**Consultation Response from KC,
Highways Development Management****2024/93345 1, Morley Lane, Milnsbridge, Huddersfield, HD3 4NR****Alterations to ground floor to form 2 apartments (within a Conservation Area)****Date Responded: 16/01/2025****Responding Officer: CNB****Responding Ref: K2-17NE/29**

This application is for a residential development of two apartments on the ground floor of an existing retail unit fronting on to both B6111 Morley Lane and B6111 Market Street.

Proposed Site Layout Plan
(Not to scale)

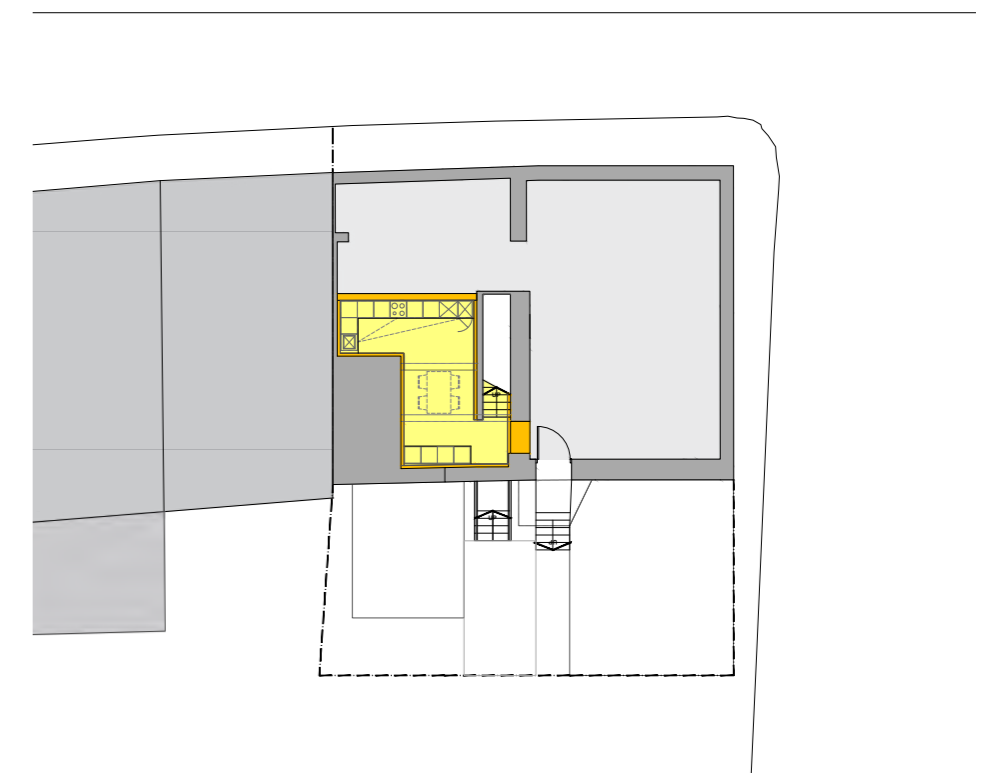
No details were provided relating to waste storage and collection, however we assume that this will be done by Kirklees Residential waste collection service as with the existing residential premises. Drawing No C1038 110 Rev2 shows the location of two wheely bins within the curtilage of the site and this would be an acceptable location for bin storage. For full waste collection requirements we would request that you consult with our colleagues in the Waste Strategy Team who can provide guidance for new developments.
